CITY OF ALBUQUERQUE

PLANNING DEPARTMENT – Development Review Services

August 18, 2015

RE: **Durango at the Trails (File: C09D012), Unit 3**
Grading and Drainage plan, Stamp Date 8-12-15 (Sheet 4)

Design Review Committee	City Engineer Approval	Last Design Update	Mo./Day/Yr.	Mo./Day/Yr.
City Project No.	Zone Map No.	Sheet	Of	
XXXXXX	C-09-Z	4	5

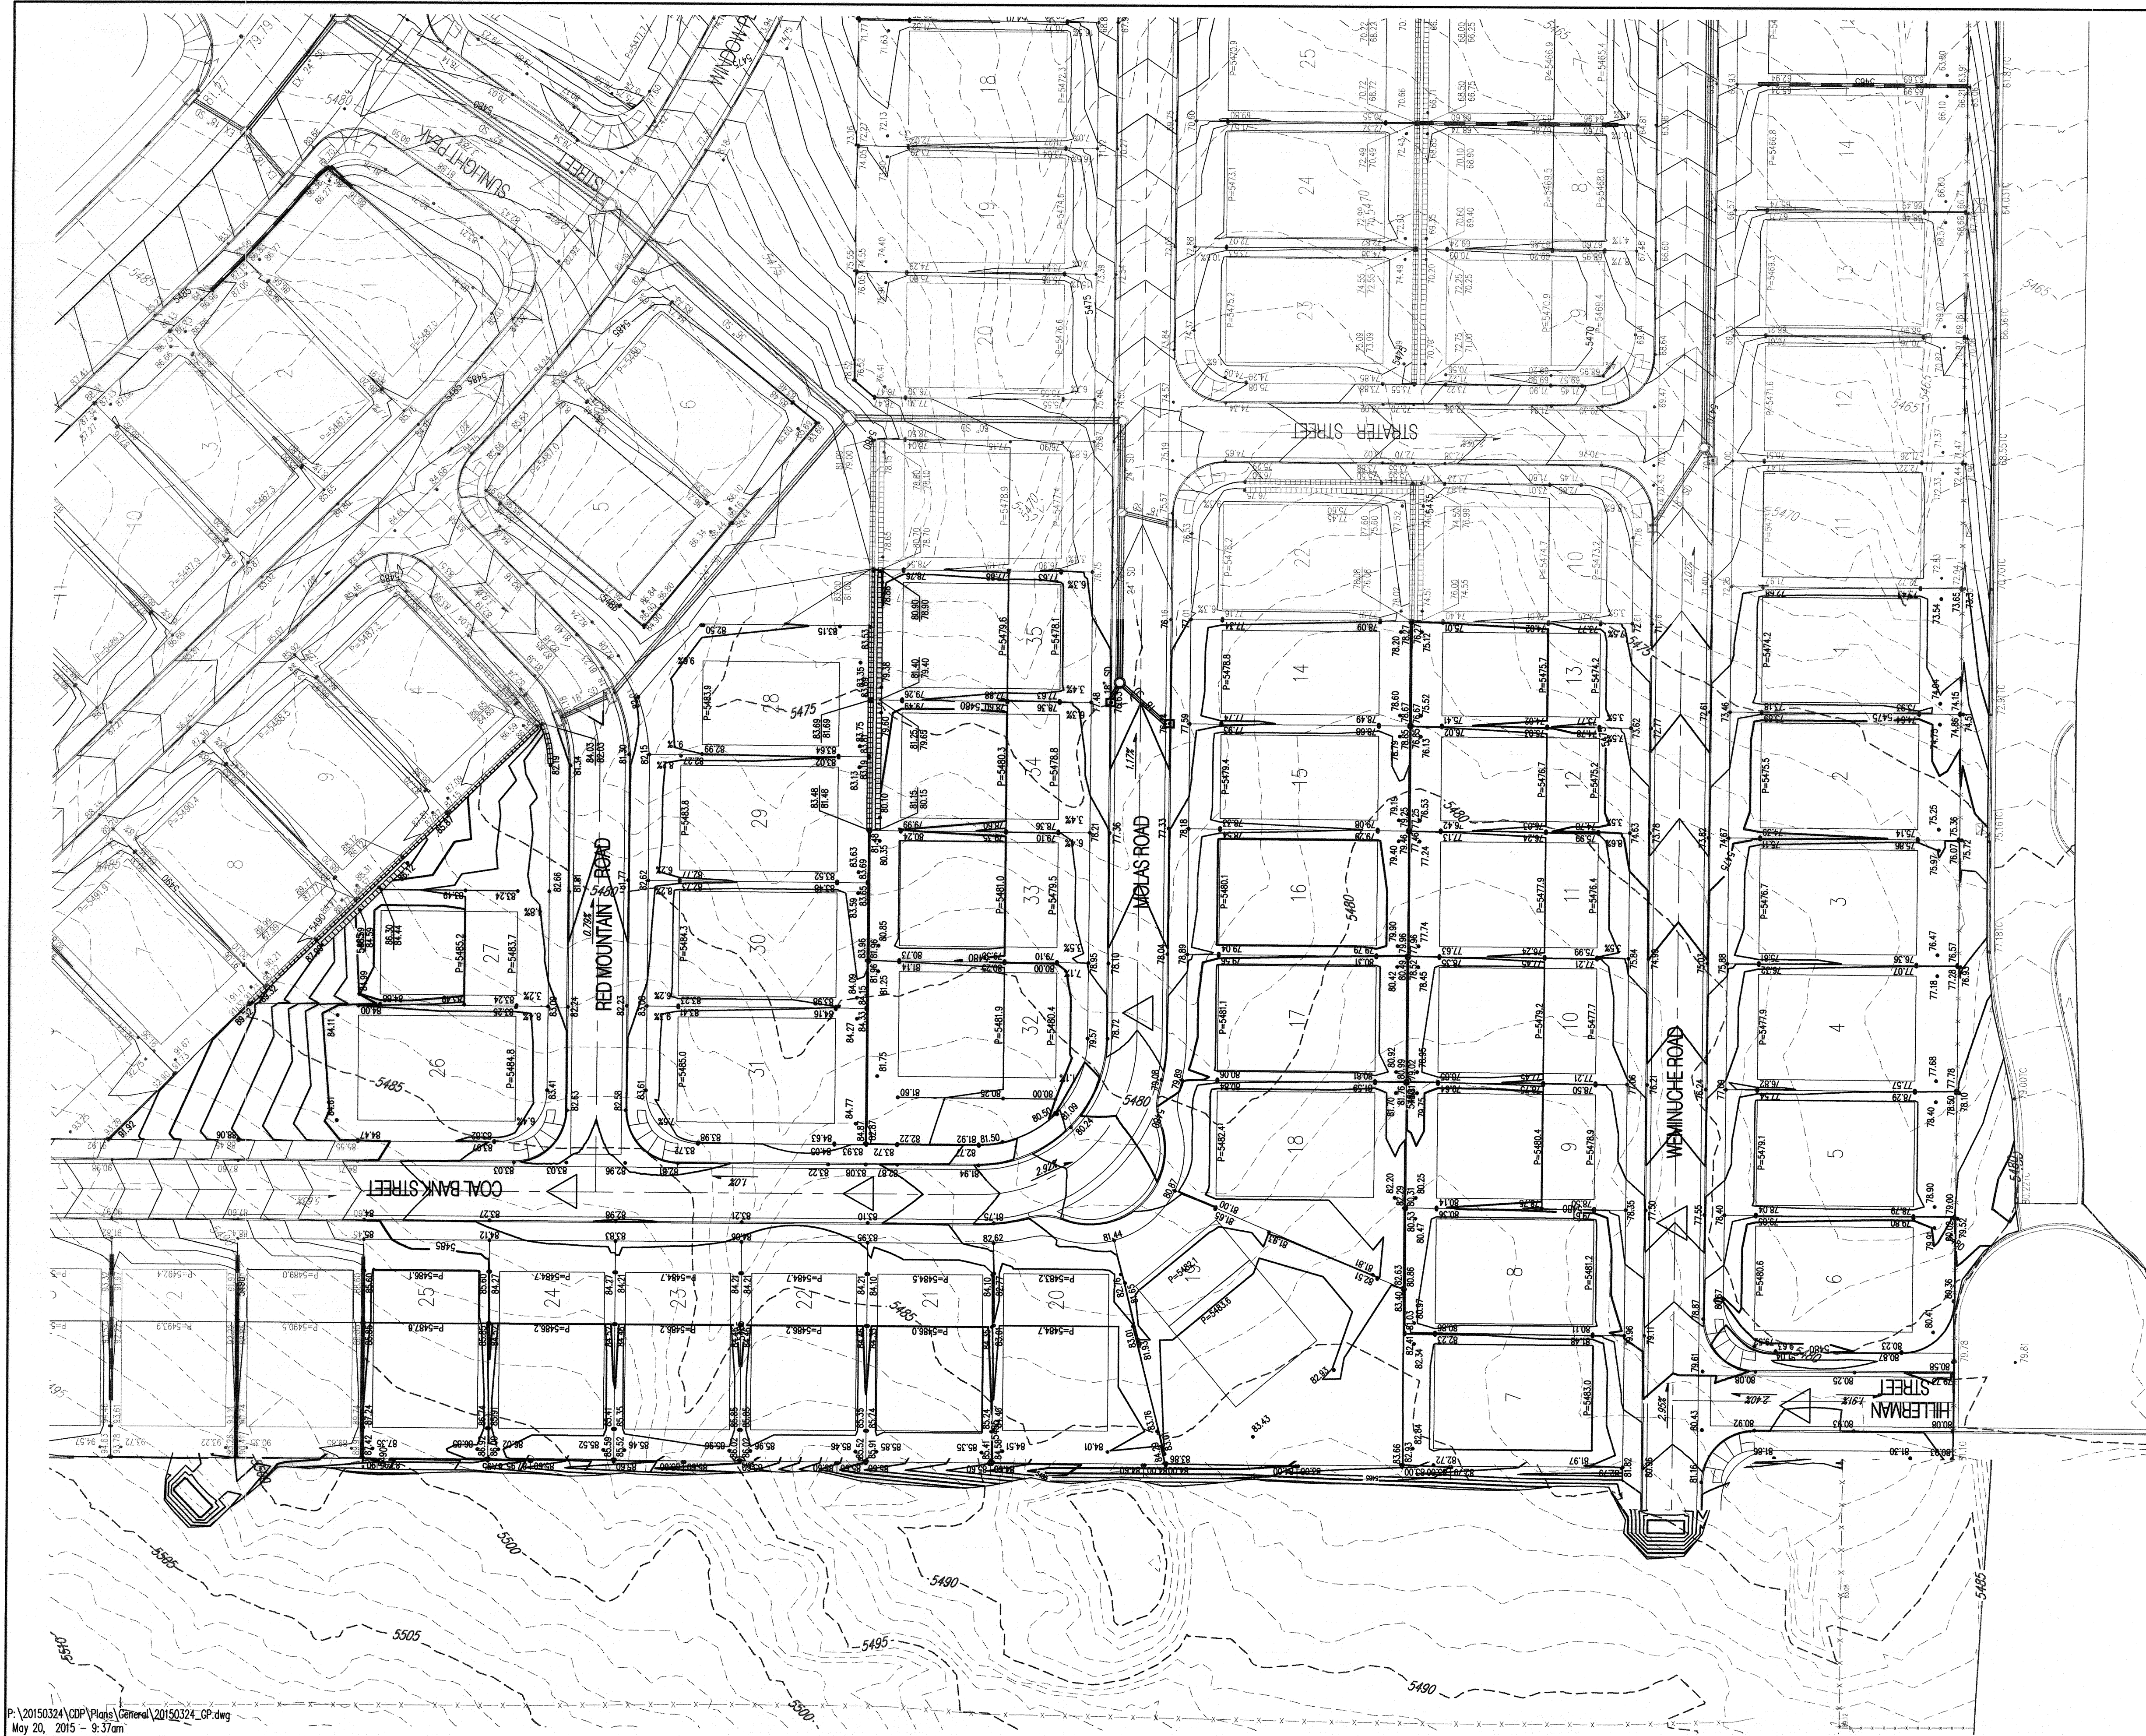
Based upon the information provided in your submittal received 8-13-15, the above referenced submittal is approved for DRB action on the Preliminary Plat and Site Plan for Subdivision *for Unit 3*. Prior to approval for Grading Permit the following comment must be addressed.

1. An Interim Grading Plan is required showing a temporary pond on Coal Bank Street where Unit 4 ties in. Temporary Drainage Easements will be required before Work Order Acceptance.
2. Items that need to be addressed on the Work Order:
 - a. It appears a valley gutter is needed to direct flows from west side of Coal Bank St. down Red Mountain Road.
 - b. Offsite runoff seems to be directed by a swale to run behind the lots down to Weminuche Road. The sediment pond should pick up those flows.
